December 14, 2006

Re: Churchill Townhomes Grading Plan
Engineer's Stamp dated 12-4-06 (K10/D50)

Re: Churchill Townhomes Grading Plan
Engineer's Stamp dated 12-4-06 (K10/D50)

GRADING PLAN

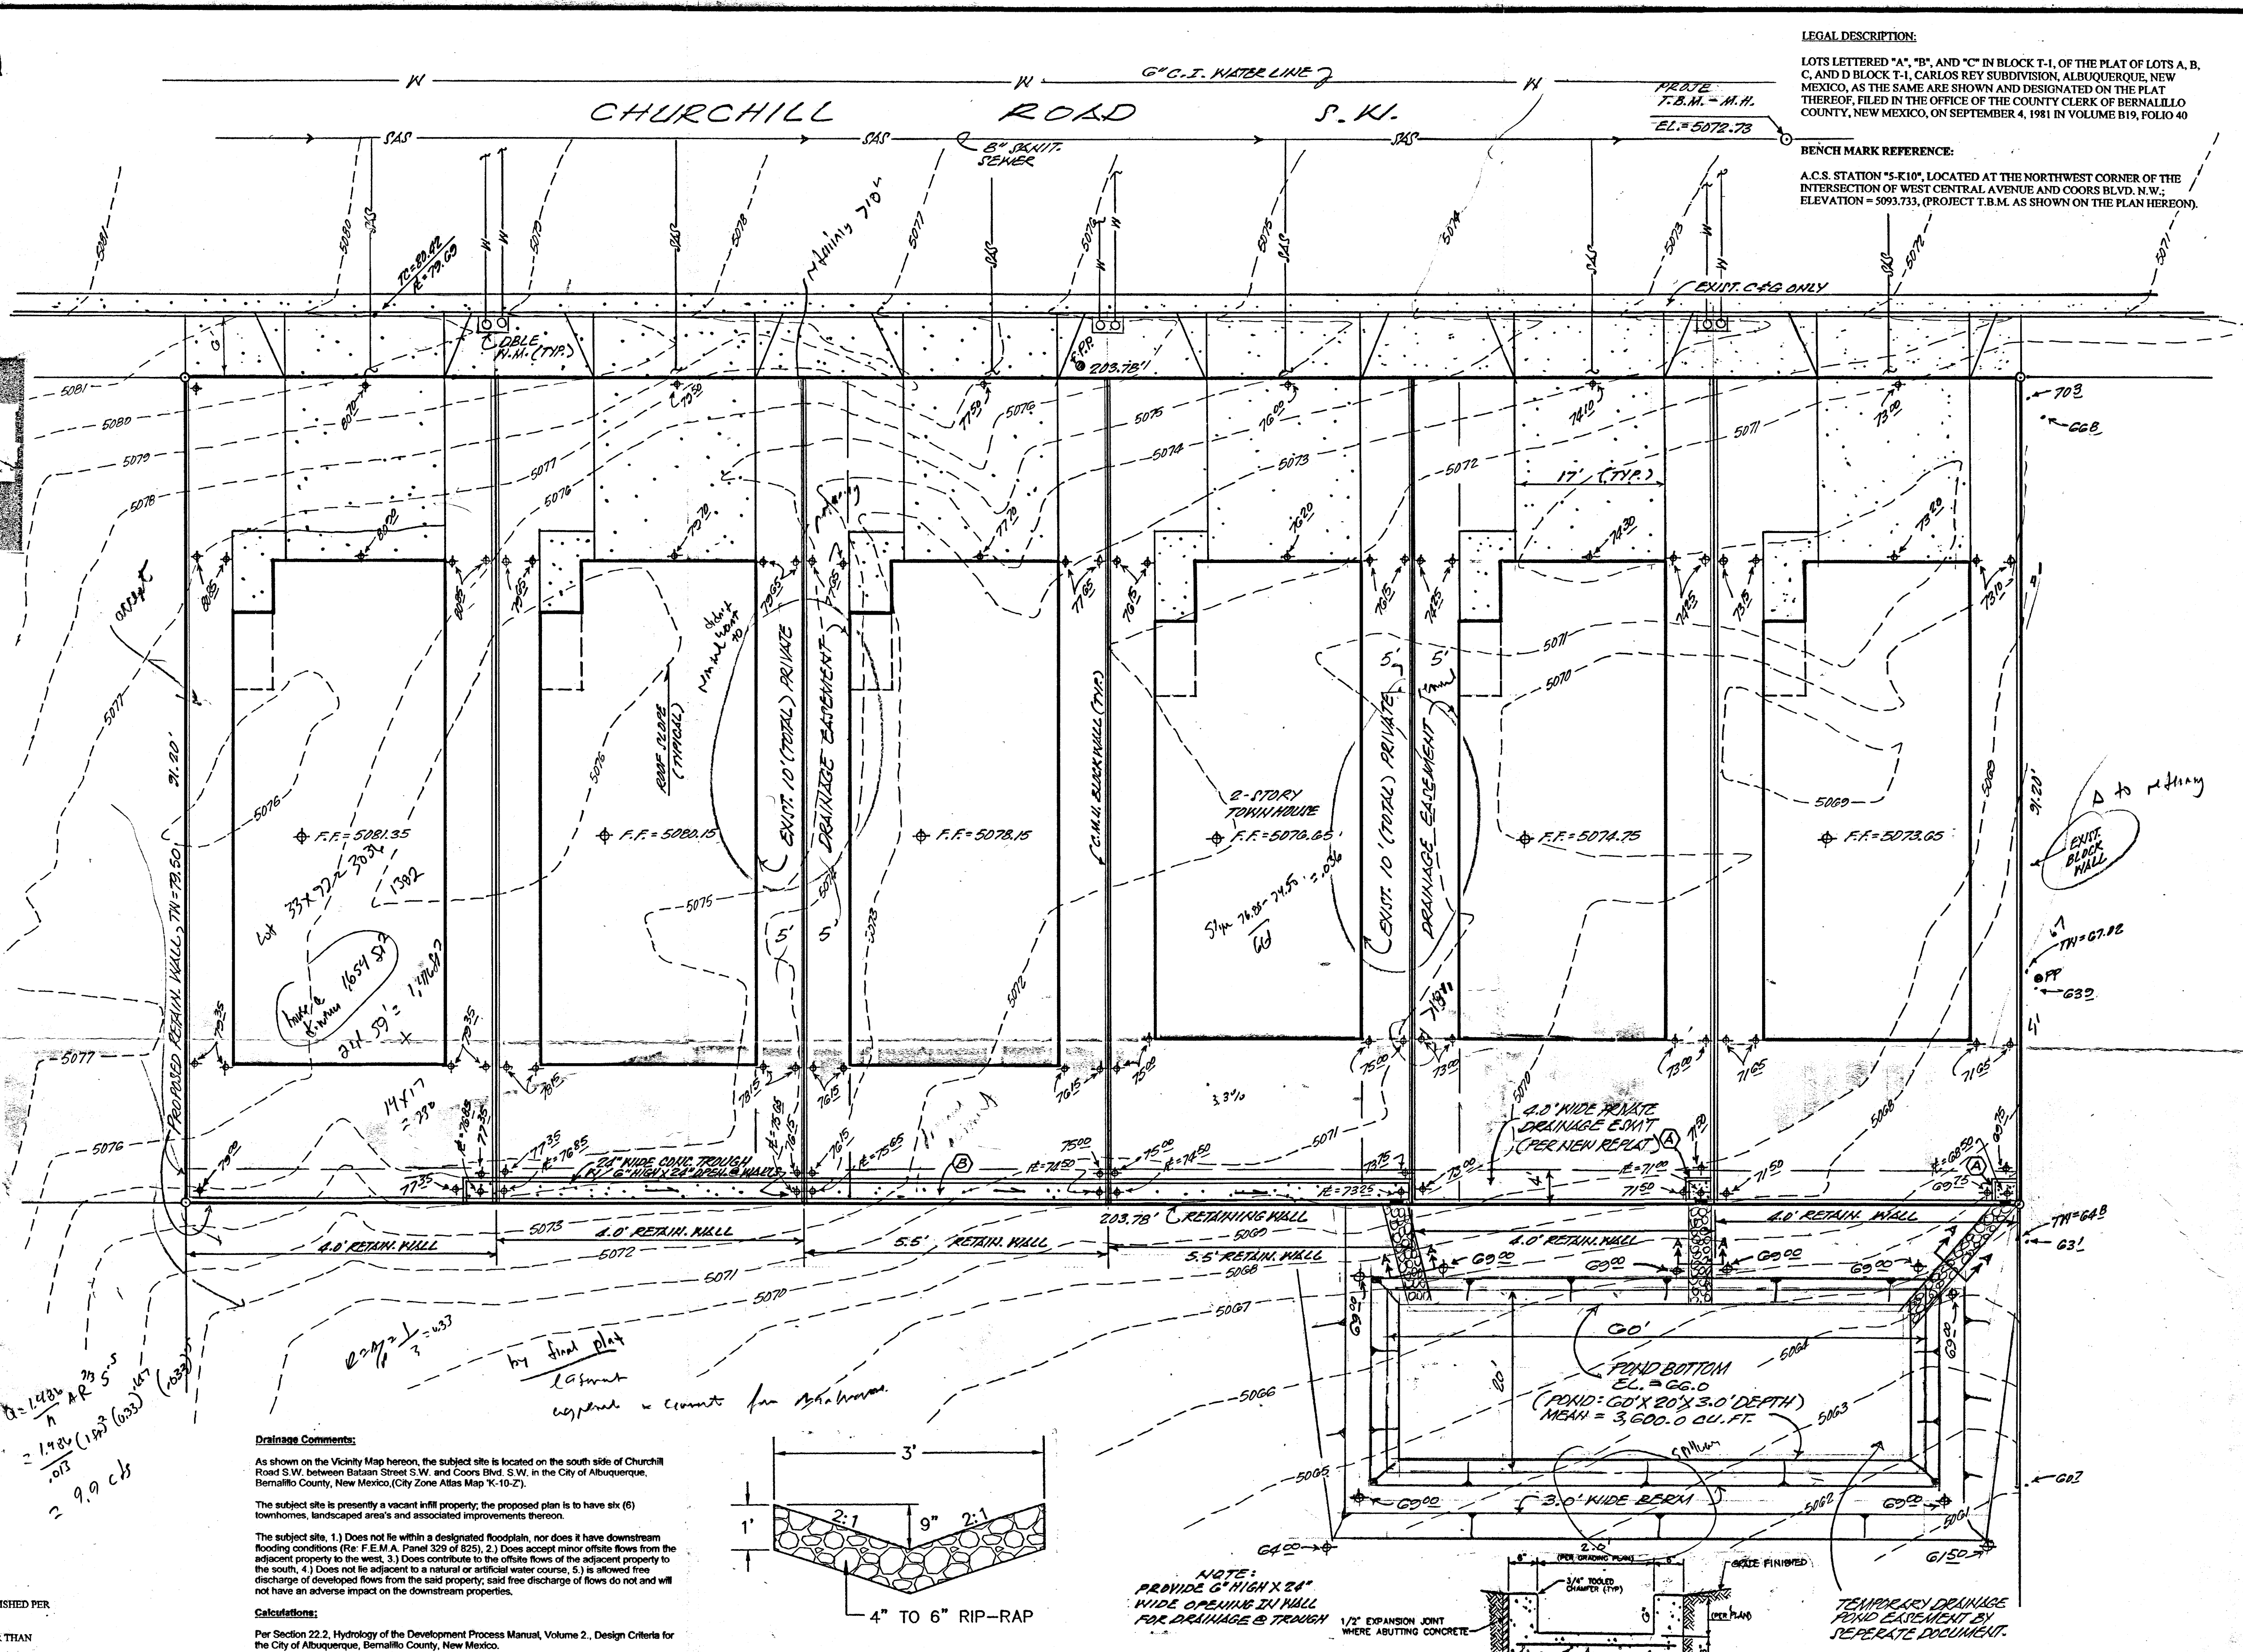
- Retaining walls are required for grade changes greater than 18". Retaining walls are required on the eastern edge of this project and between a couple of lots.
